Application Ref:	3/2026/0370			 Ribble Valley Borough Council www.ribblevalley.gov.uk
Date Inspected:	29/05/26	Site Notice:	N/A	
Officer:	AR			
DELEGATED ITEM FILE REPORT:				APPROVAL

Development Description:	Proposed demolition of existing garage, erection of new two-storey side extension and single-storey rear extension.
Site Address/Location:	62 Fairfield Drive Clitheroe BB7 2PS

Drawing Title
Proposed Elevations

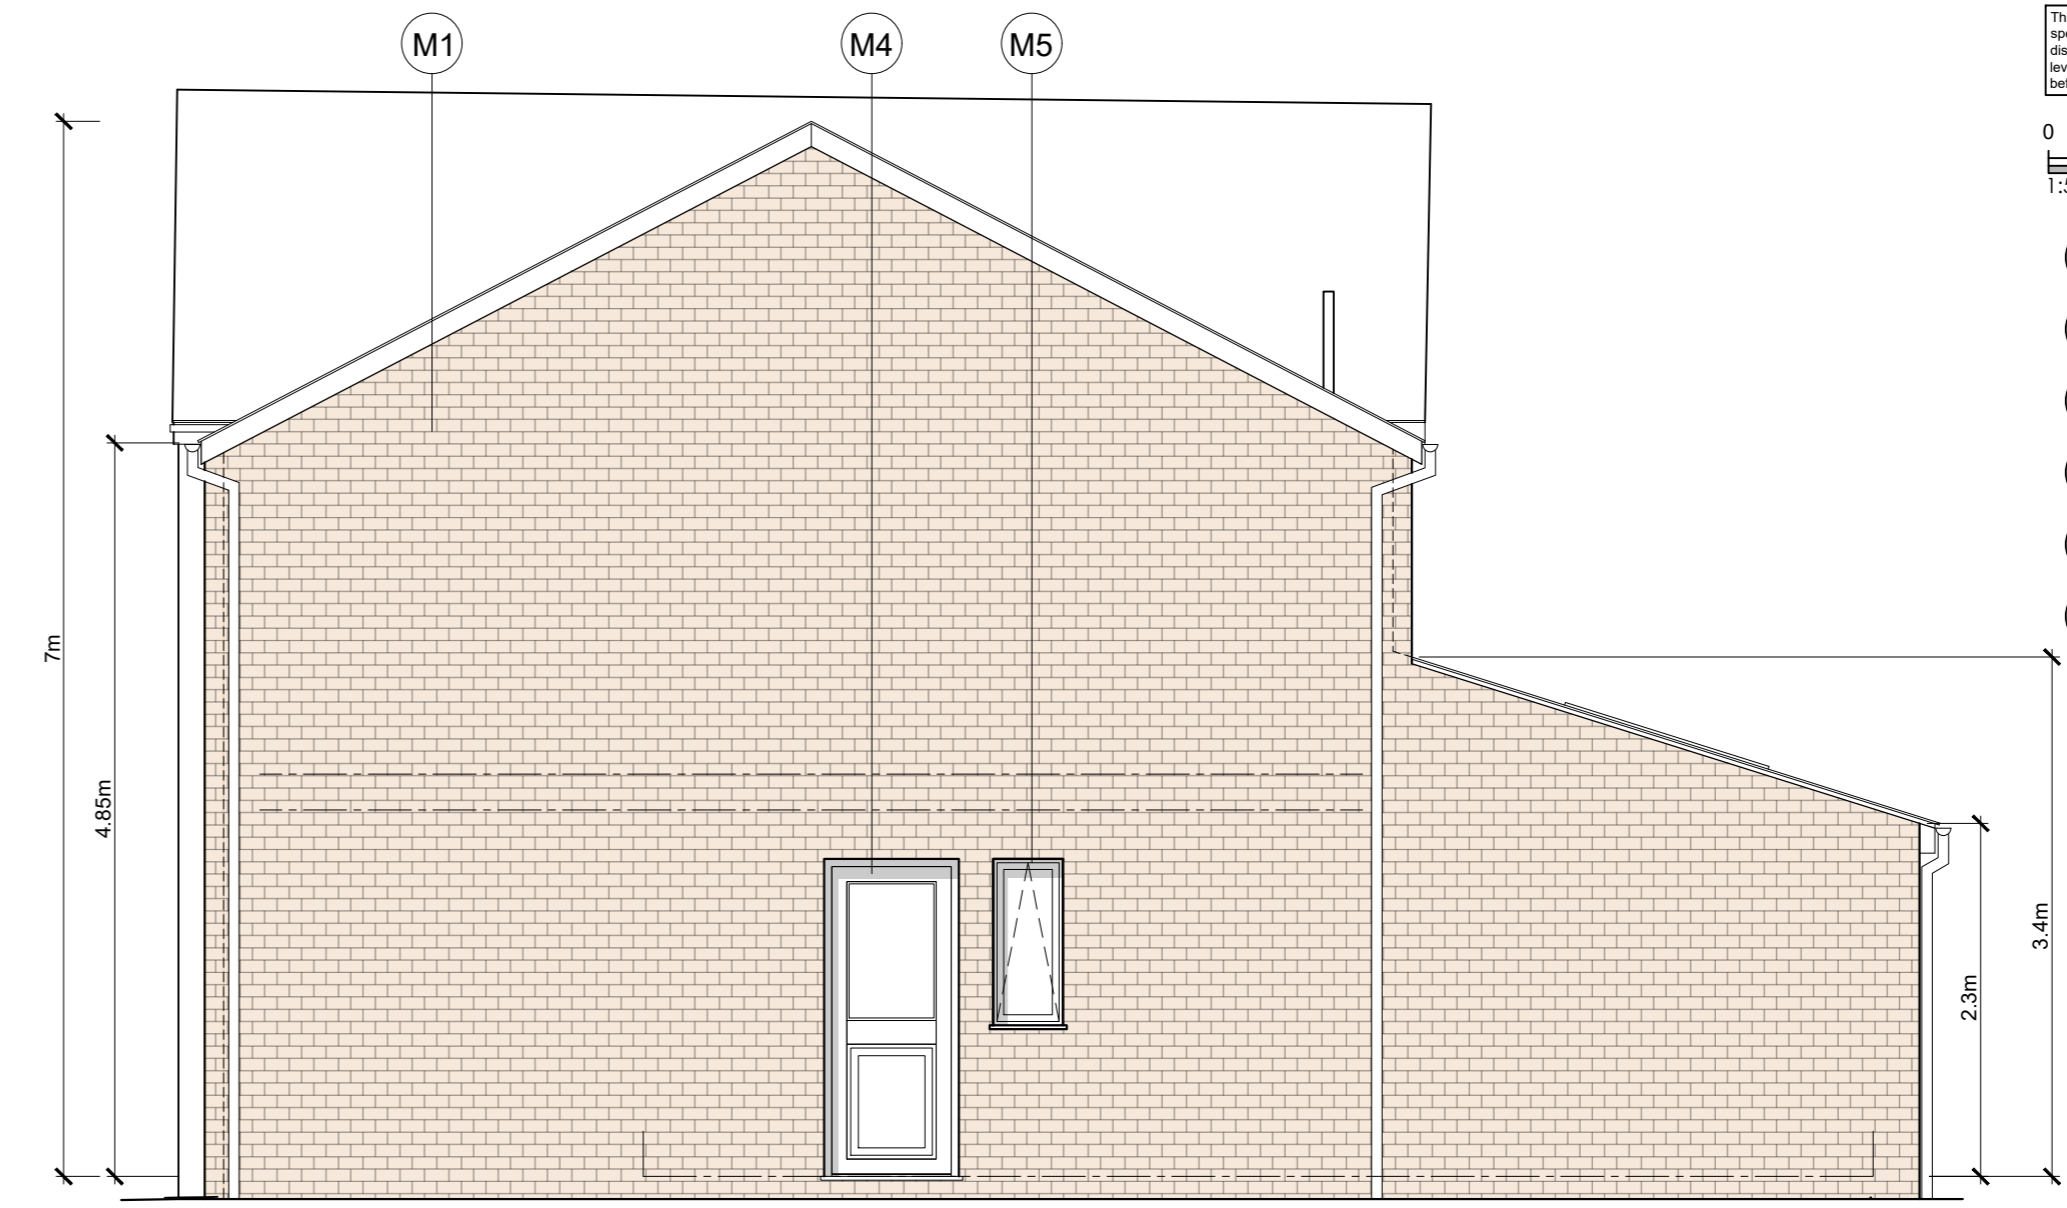
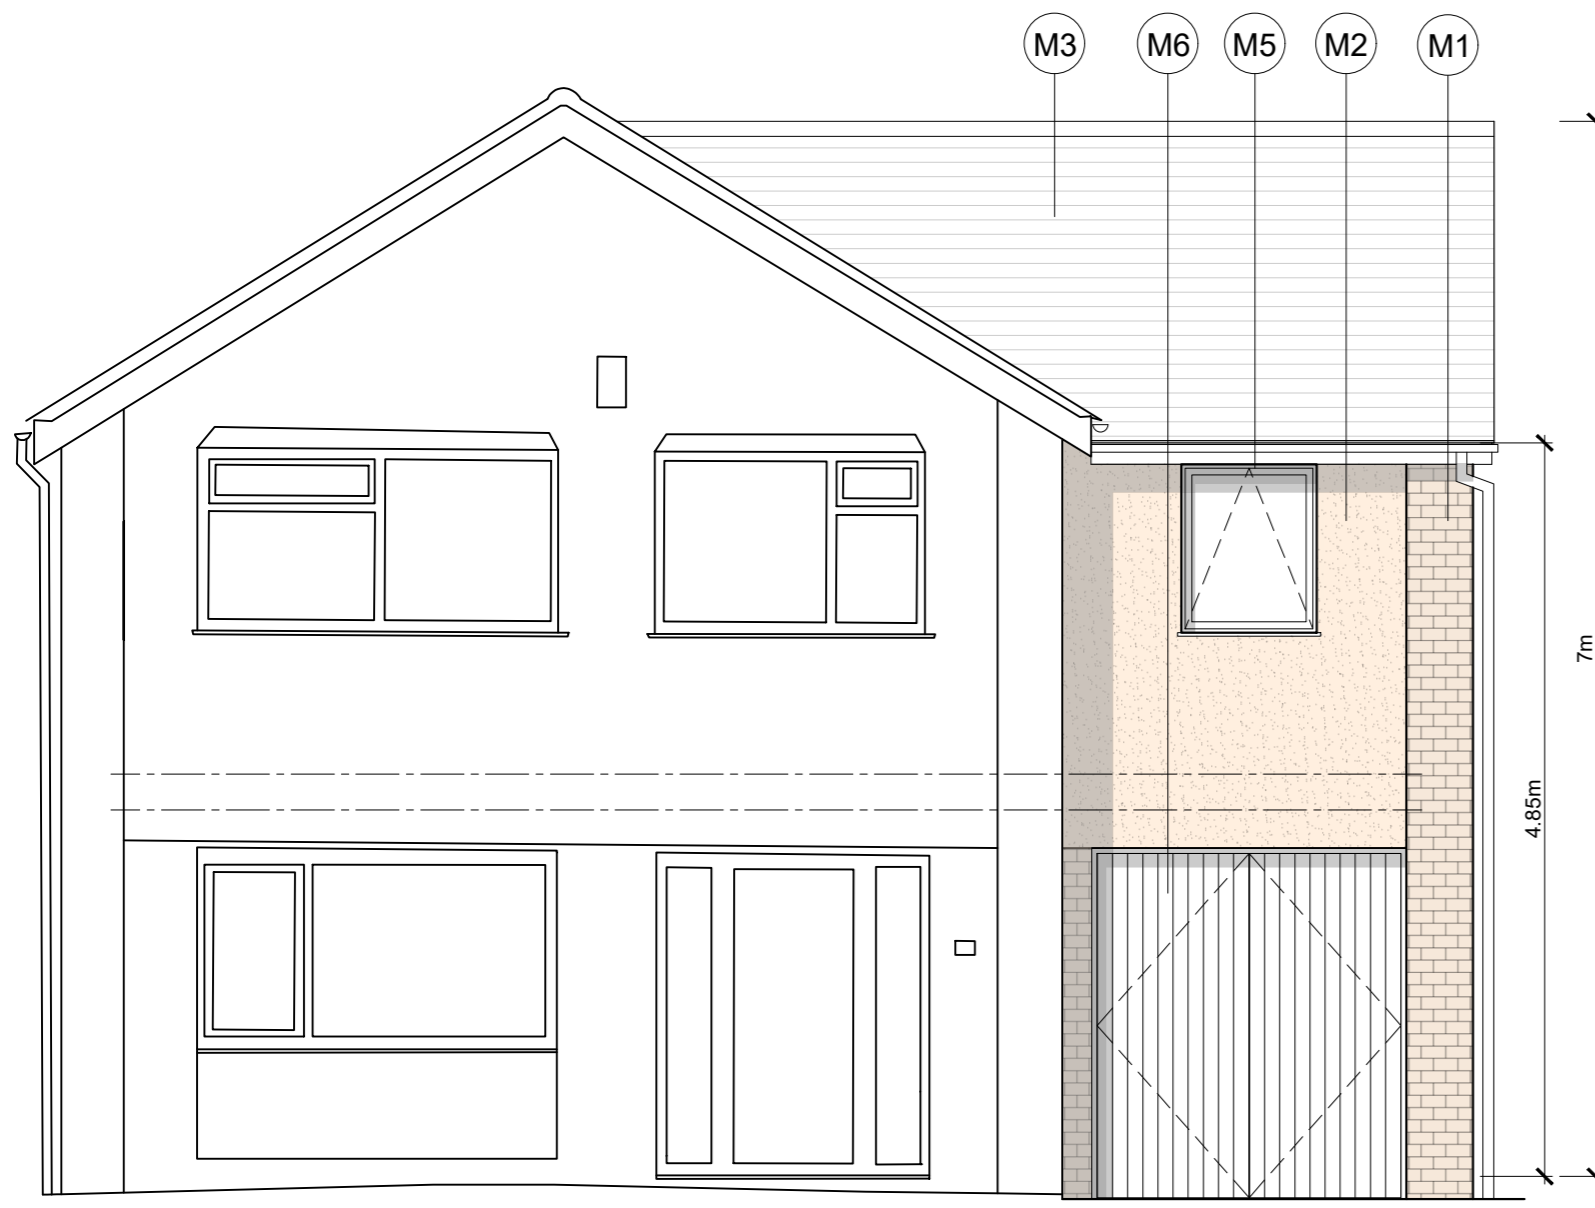
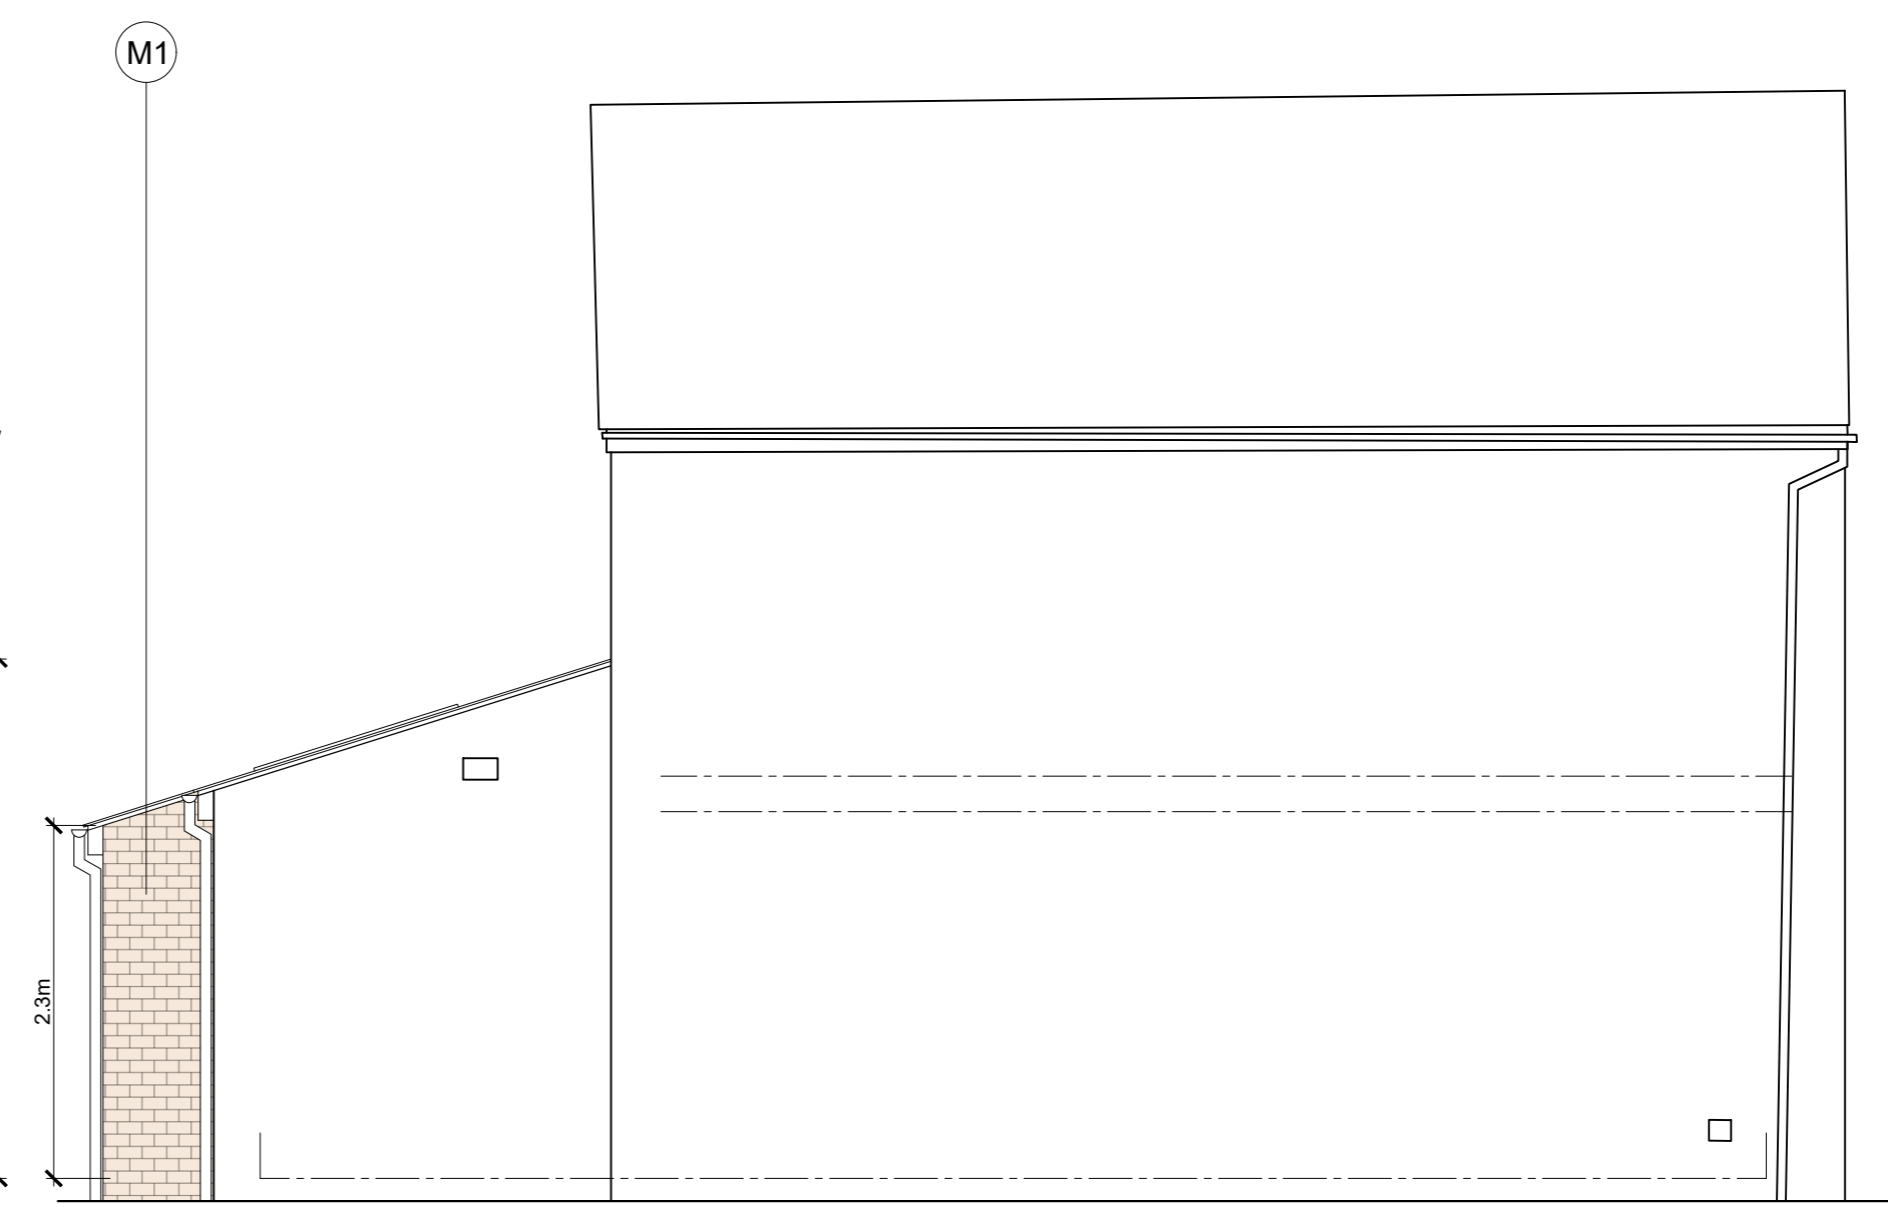
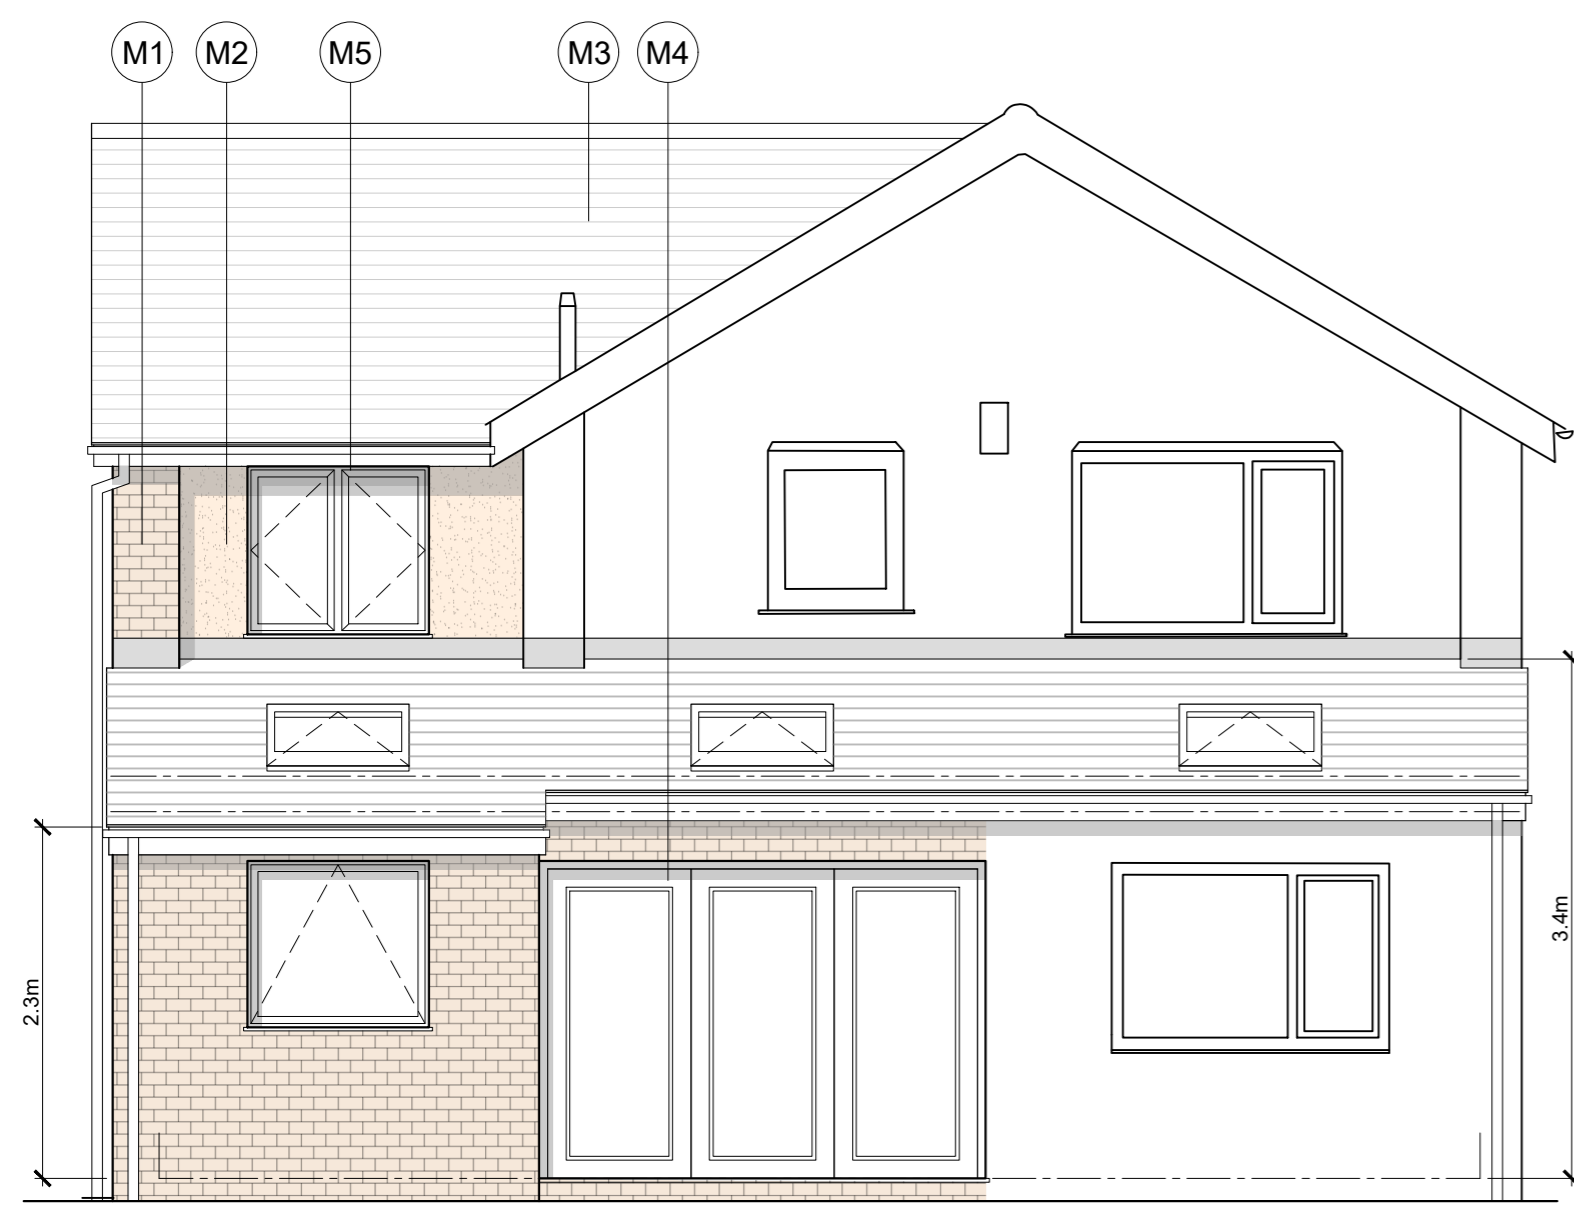
With respect to potential overlooking, the proposed development includes only one window on the north-west side elevation. This window faces the side elevation of 60 Fairfield and is located in a non-habitable room, thereby preventing any loss of privacy. Additionally, both the window and door on the side elevation of No. 60 Fairfield are obscure glazed, further indicating that these openings do not serve habitable rooms. Furthermore, the proposed development would not bring the application property any closer to the neighbouring property known as No. 60 Fairfield, with the existing and proposed side elevations being situated 1.8m away. Whilst the proposed extension would introduce a greater scale and massing along the boundary, in light of the existing windows at no.60 being obscure glazed no concerns are raised in respect of overbearing impact or loss of light.

The proposed two-storey extension would project 2.74m from the north-west side elevation of the application property and would be slightly set back from the principal elevation by approximately 0.3 m and would be set down from the ridgeline of the main dwelling by 0.2m. In this respect, the proposed development would take a subservient position in relation to the primary dwelling house and would not read as an overtly incongruous or over-dominant addition to the immediate or wider locality.

With regard to materiality, the proposed extensions would feature render to the upper elevations and red brick to the lower elevations, interlocking roof tiles, grey aluminium/UPVC doors, grey UPVC windows, and barn doors to the front elevation, to be finished in timber cladding.
